<b>Application Ref:</b>	3/2025/0078			 <p>Ribble Valley Borough Council <a href="http://www.ribblevalley.gov.uk">www.ribblevalley.gov.uk</a></p>
<b>Date Inspected:</b>	25/03/2025	<b>Site Notice:</b>	25/03/2025	
<b>Officer:</b>	MC			
<b>DELEGATED ITEM FILE REPORT:</b>				<b>APPROVAL</b>

<b>Development Description:</b>	Listed Building Consent for proposed demolition of existing extensions and erection of part single, part two storey extension and alterations.
<b>Site Address/Location:</b>	Top Lodge, Browsholme Hall, Clitheroe Road, Whitewell, BB7 3DE

SHEET: PROPOSED ELEVATIONS 1

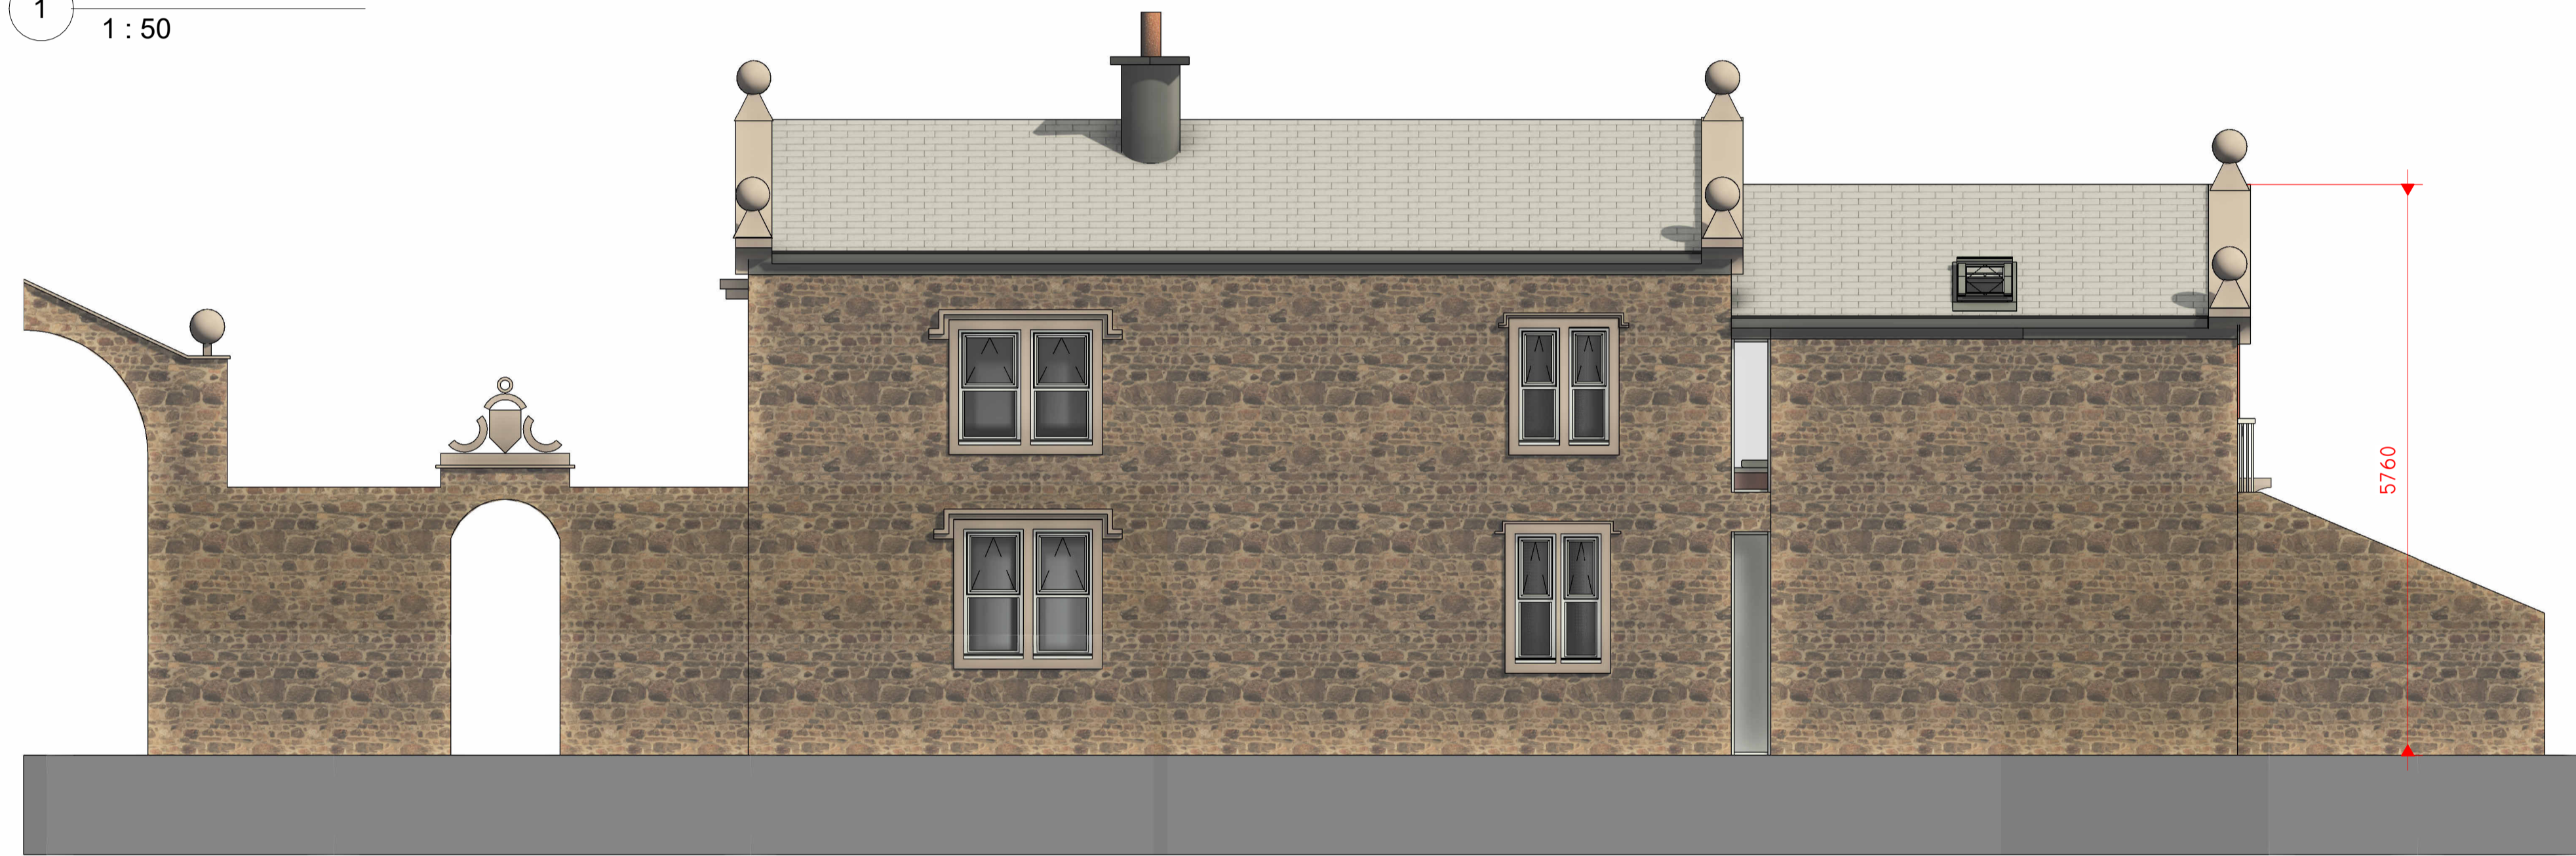
With regards to the impact on the Listed Building, the Heritage and Conservation Officer has provided comments on the scheme. In their original comments, concerns were raised regarding the amount of double

doors in the East Elevation which were considered to be excessive. A Juliet balcony is proposed and the steel handrail has now been amended to a more traditional railing which whilst has removed some of the harm, the amount of glazing is still considered to be harmful.

The Heritage and Conservation Officer also considers that the tall, narrow window on the proposed South Elevation is slightly discordant with the host building but notes that the window which adjoined the rooflight has been amended to a traditional rooflight. They recommend the glazing details, including the rooflight are secured by way of condition.

The Heritage and Conservation Office does not feel that the harm is completely removed and the development represents a very low level of less than substantial harm, caused by the proposed excessive openings and tall narrow light appearing discordant against the historic building, in a traditionally designed extension.

Juliet balcony at first floor level. The detailing of the Juliet balcony has been amended prior to the determination of the application to include more traditional metal railings.

The extension would include a modern glazed, narrow window at ground and first floor level to the south elevation and a rooflight inserted into the south roof slope. This has been amended prior to determination from a large rooflight/window following discussions with the Heritage and Conservation Officer.
